NW Bicester Eco Development

Transport Assessment: Addendum – 5th April 2011

Project  
**BICESTER  
 ECO DEVELOPMENT**  
 PROPOSED SITE LAYOUT  
 PLAN  
 (SOUTHERN ELEMENT)

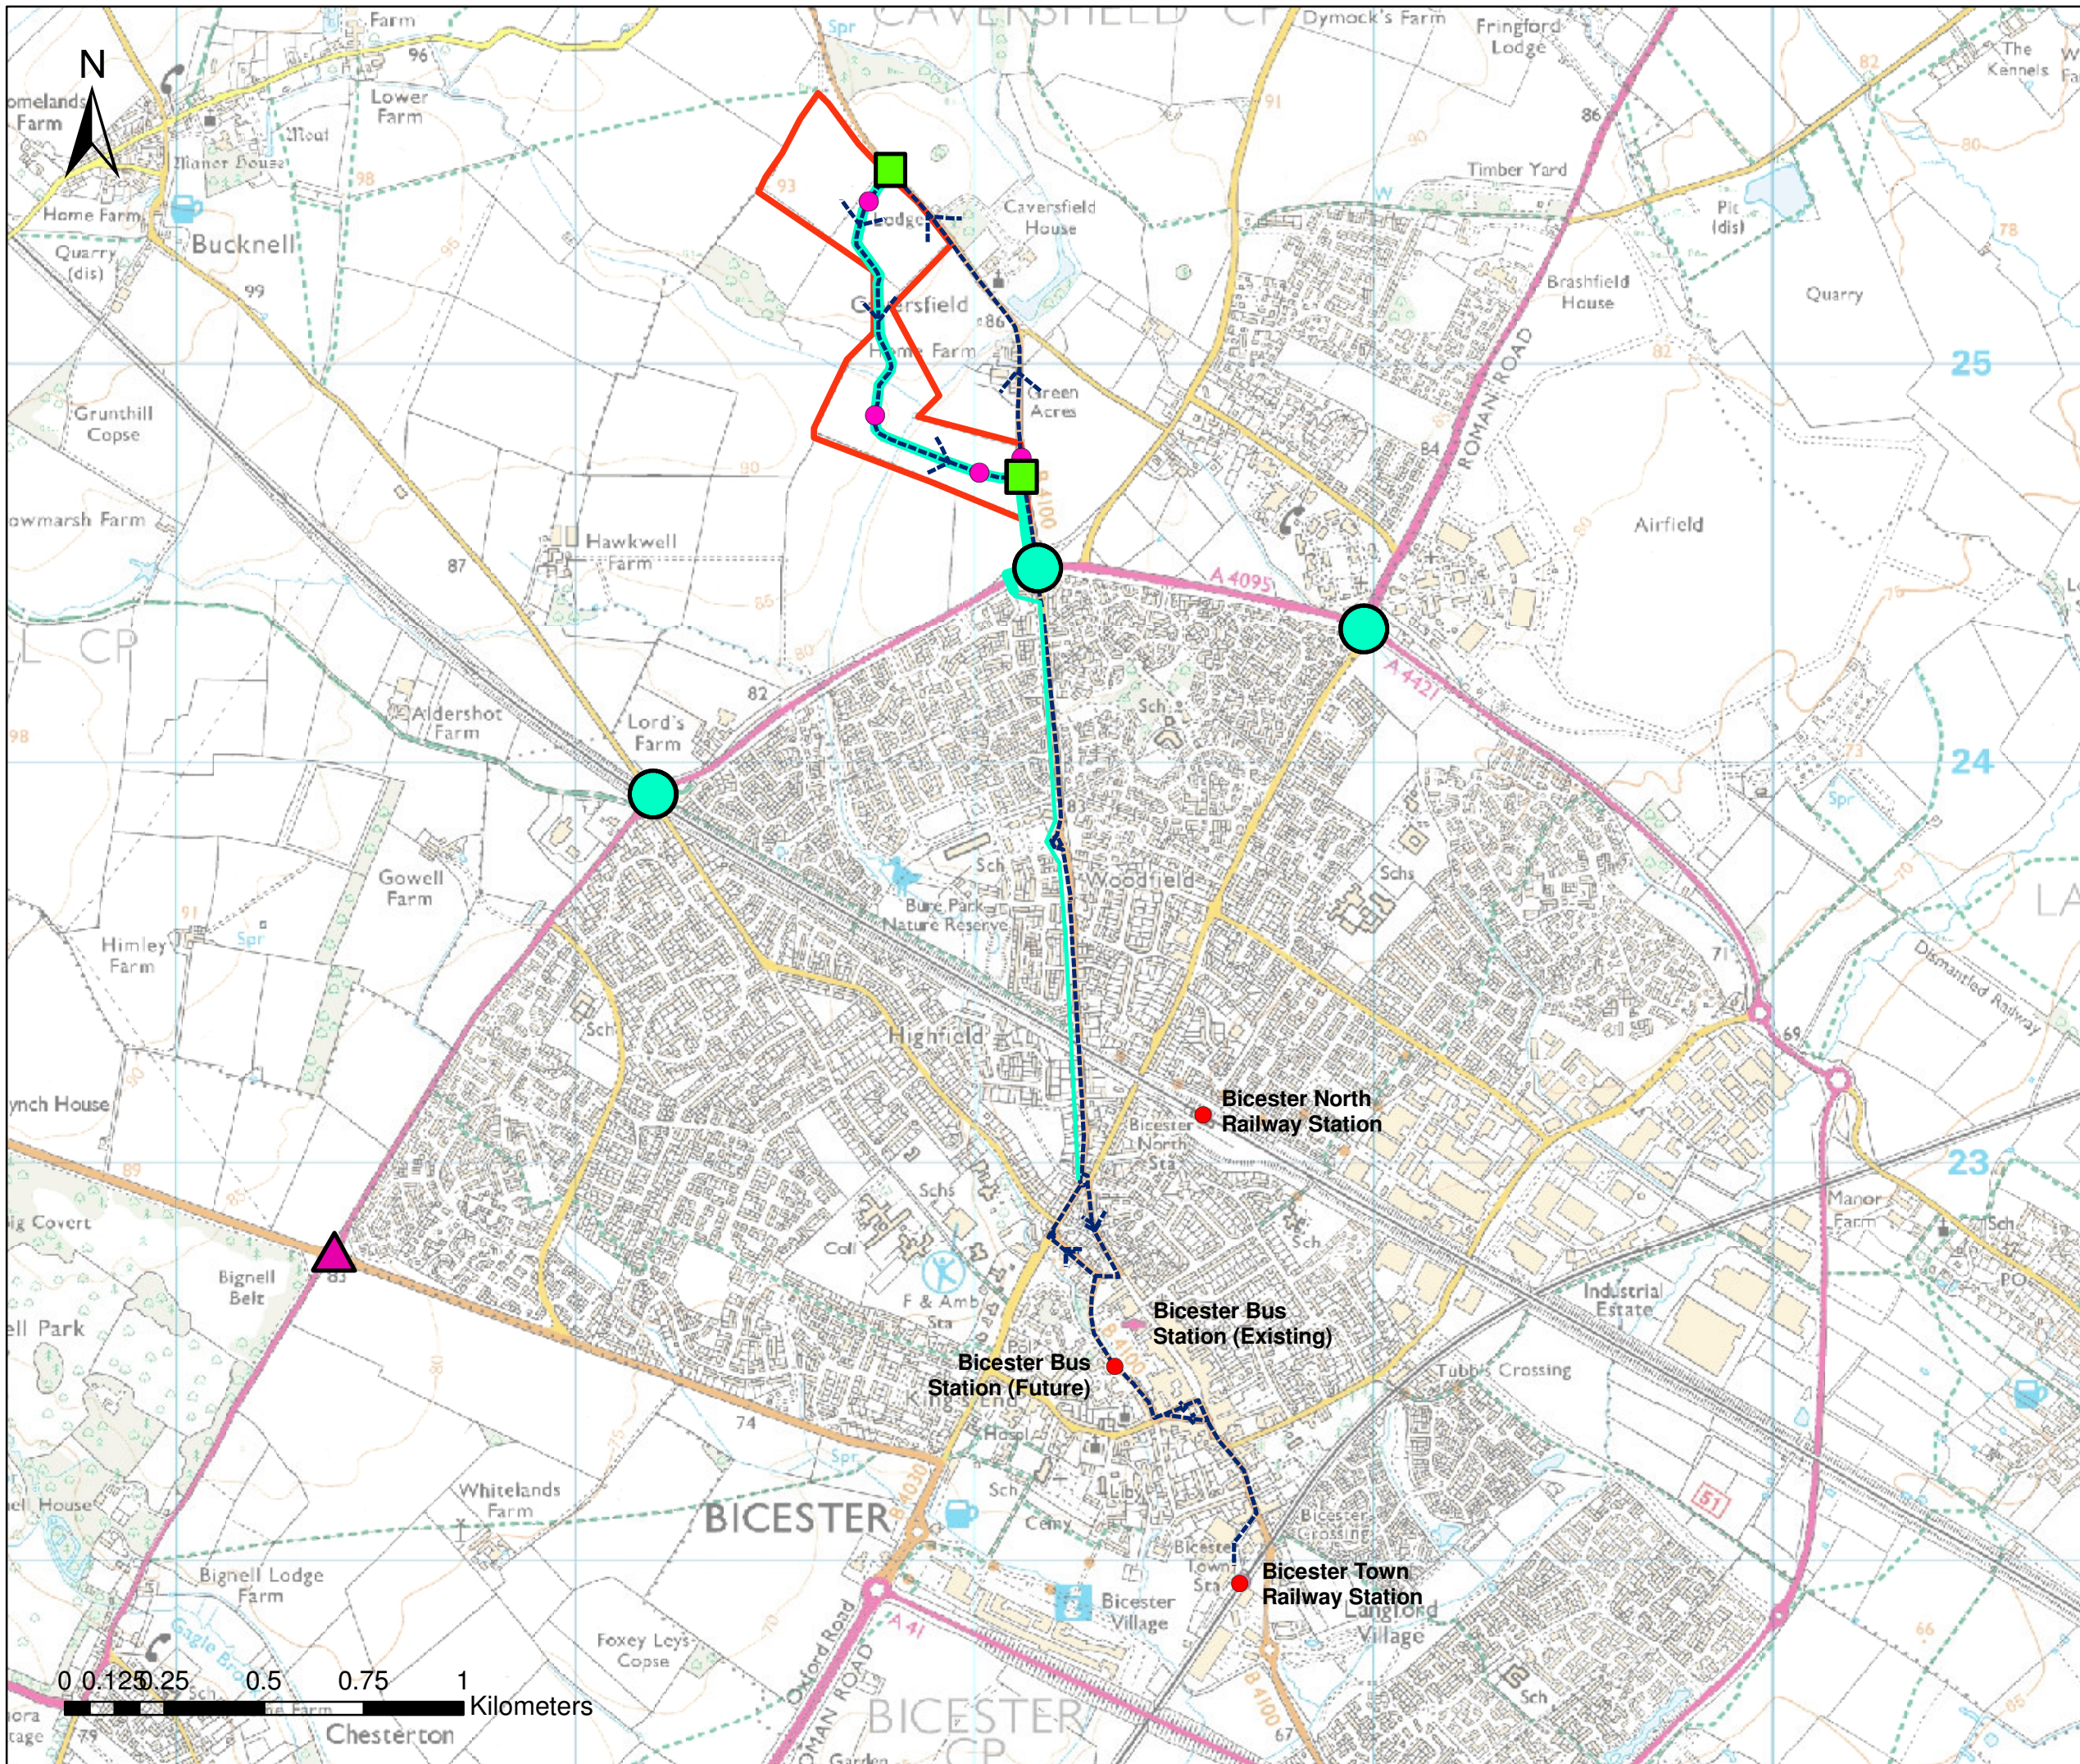
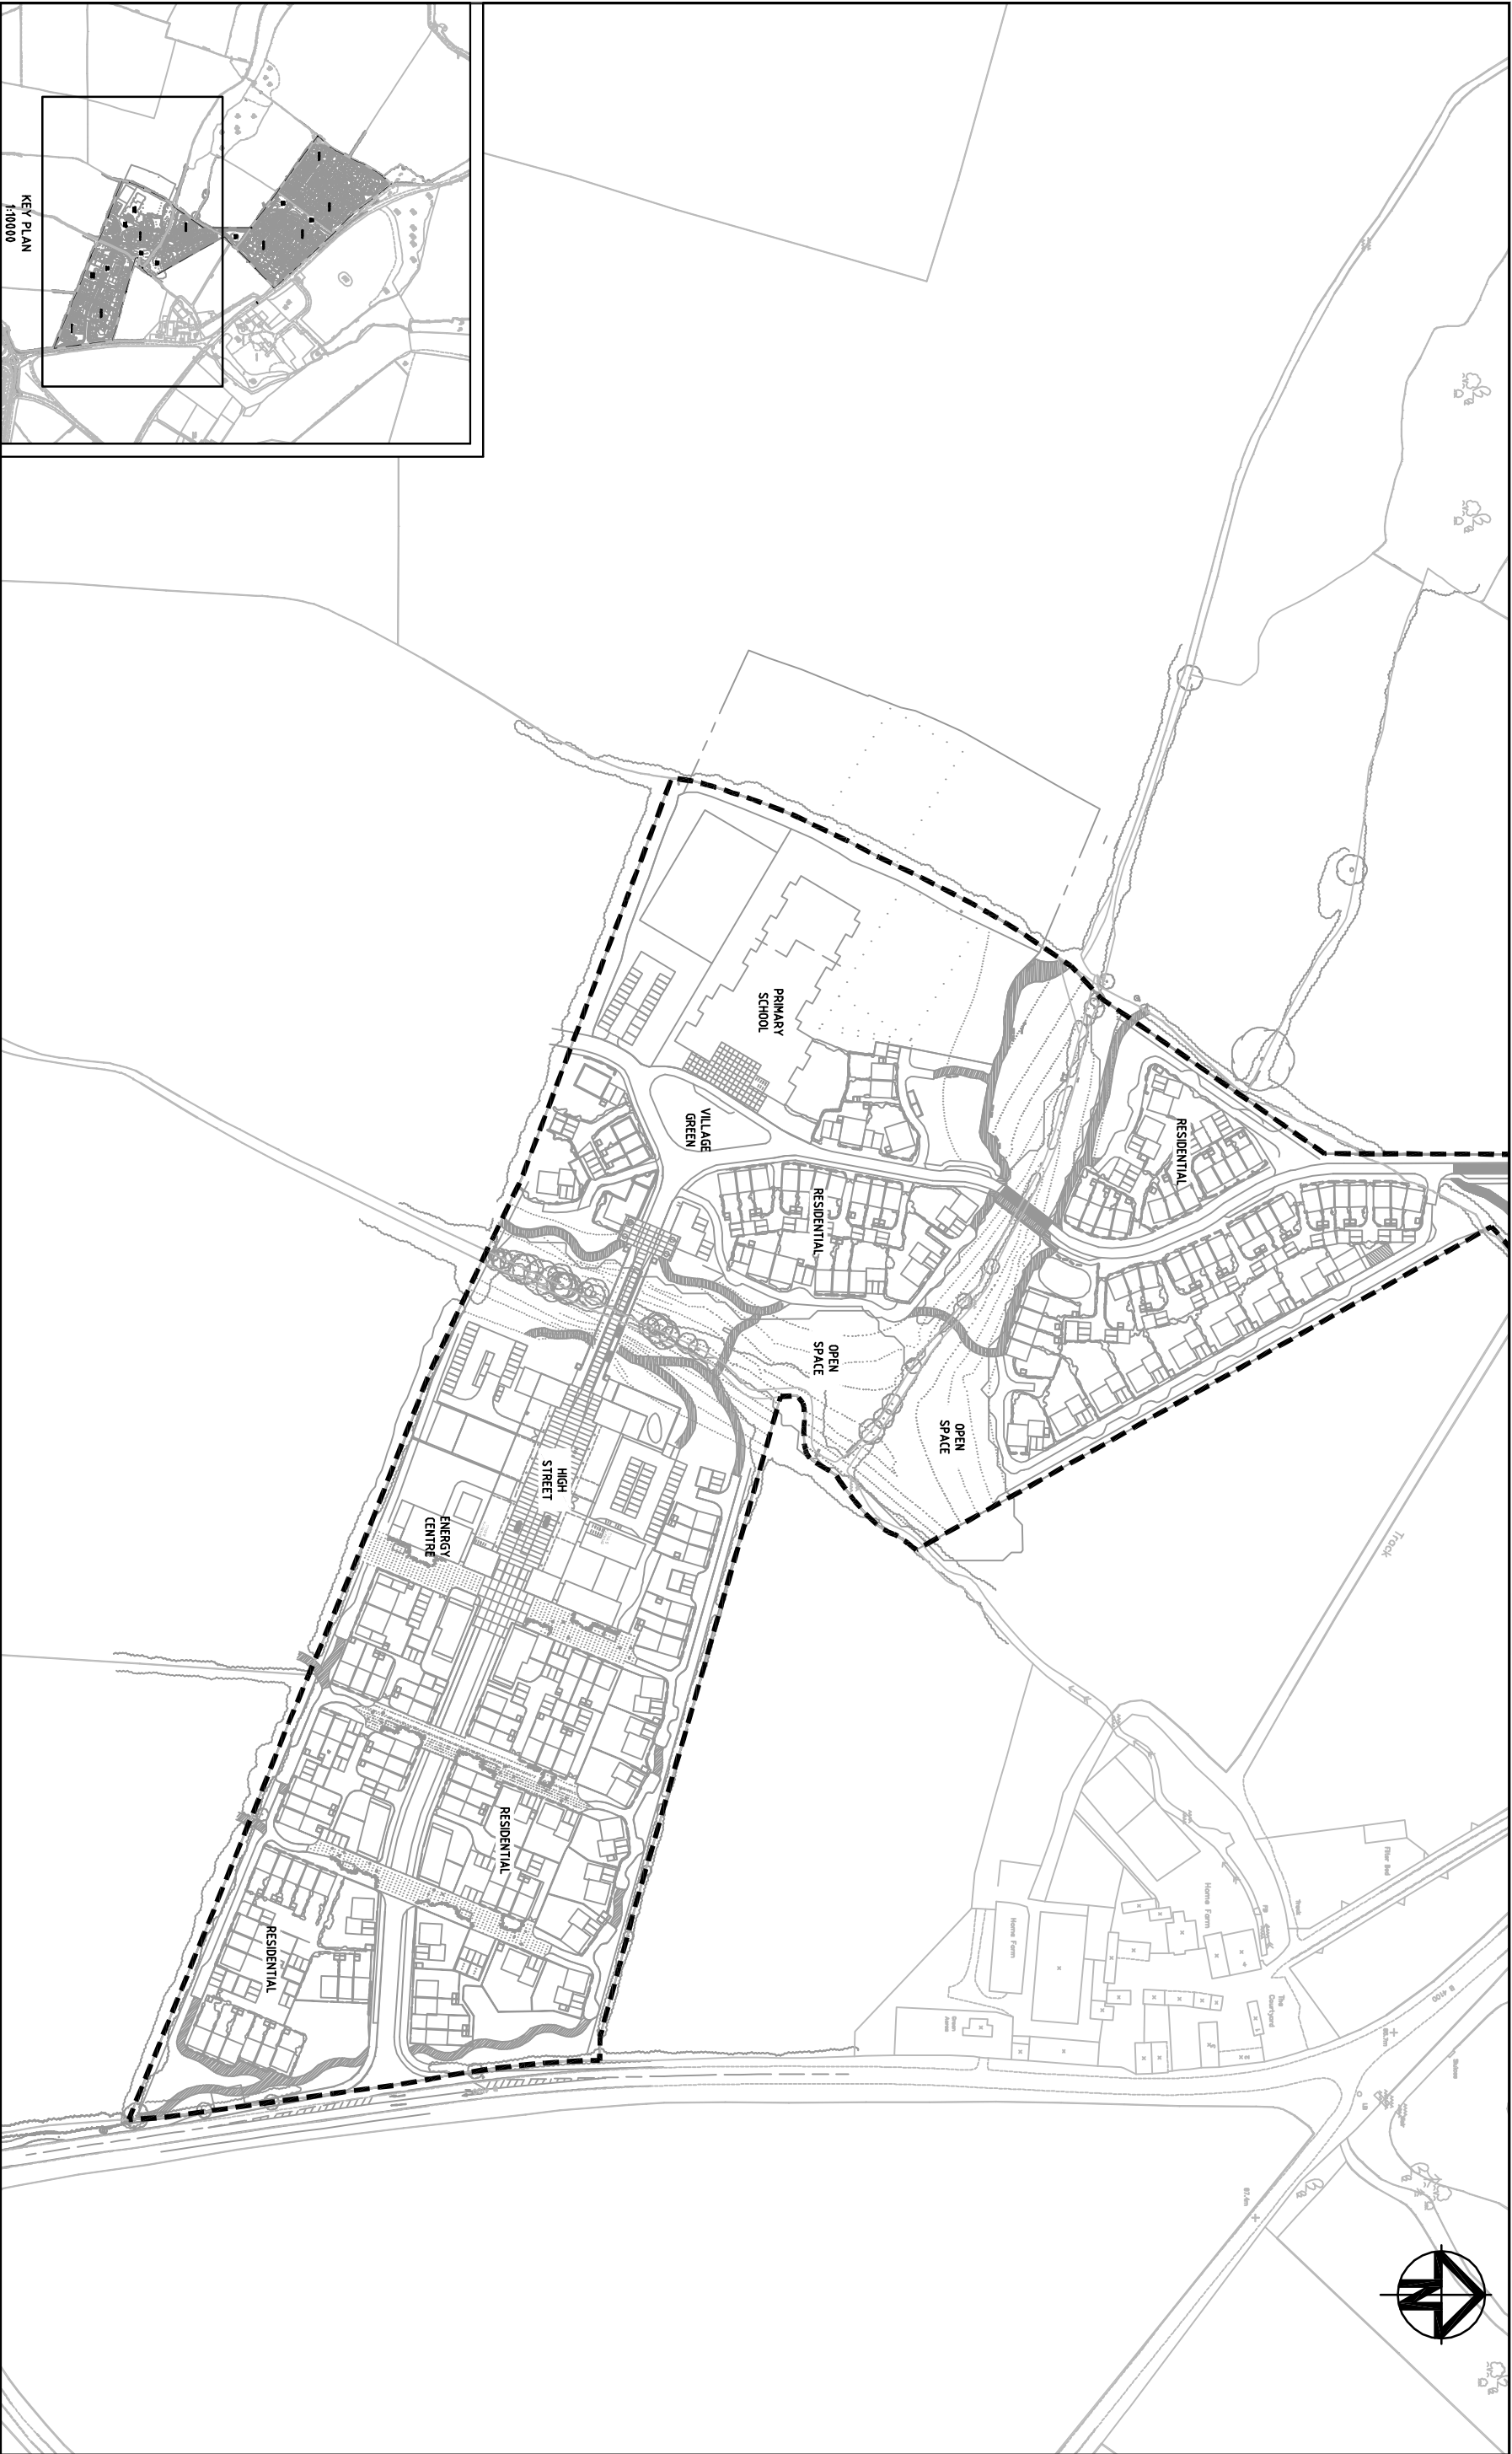
The layout of the northern fields has been revised and incorporates a road hierarchy with a central spine road of 6.0 metres width with traffic calming features, designed to a 20mph speed limit. A spur road is proposed of similar standard to the west which in the long term will provide a connection to fields to the south west. From these routes, there will be a network of minor access roads, access ways and home zones, all designed to low traffic speeds and giving priority to pedestrians and cyclists. The revised layout includes for a network of segregated

walking and cycling routes providing direct links north to south within each part, and west to east between the two parts in the northern fields and on road routes through the development, with surfacing and features designed to discourage traffic speed.

Figure 5.3

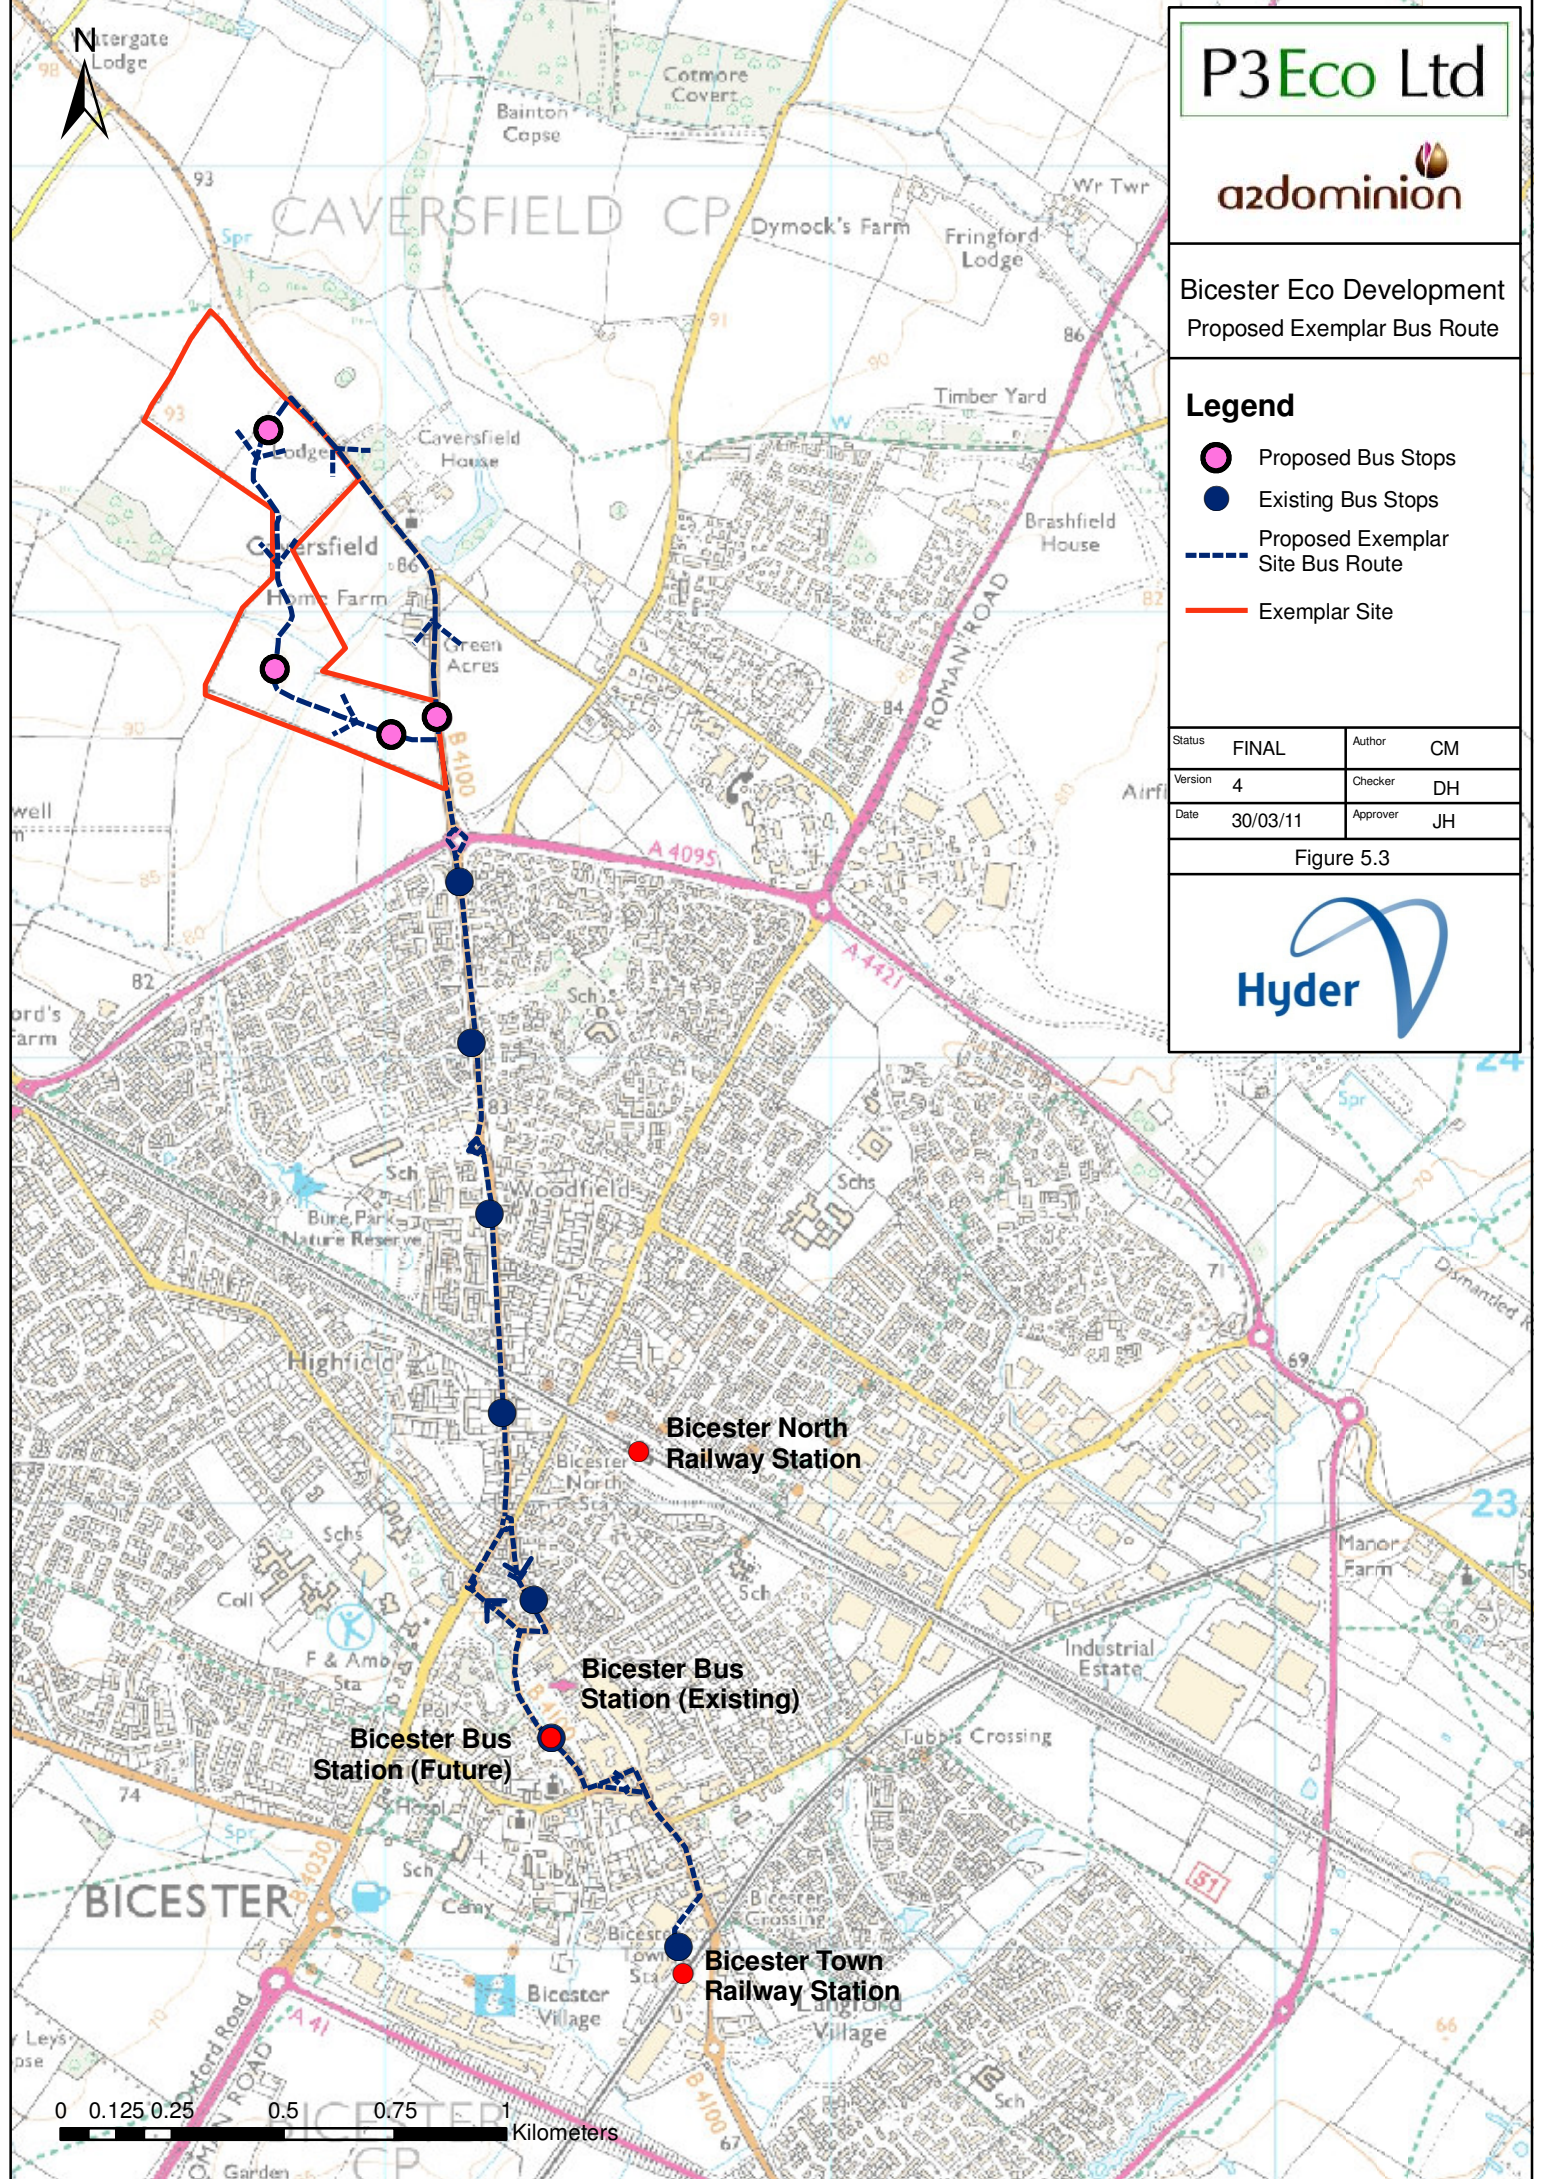
The proposed bus route is shown in **Figure 5.3**. It is proposed that the bus route is one way in an anti-clockwise direction, entering the site at the northern access from Banbury Road, travelling through the spine route and exiting via the southern access to Banbury Road.

The bus route is proposed in two phases, with the first going from the site to Bicester North Station and the town centre (prior to 2013 when the new Chiltern service is anticipated to open) and then post the new service, re-routing to the town centre and Bicester Town Station, with early morning and late evening connections to Bicester North to serve the London trains. The services will be integrated in timetable with the existing Bicester North Station services and the proposed enhanced rail services from Bicester Town Station.
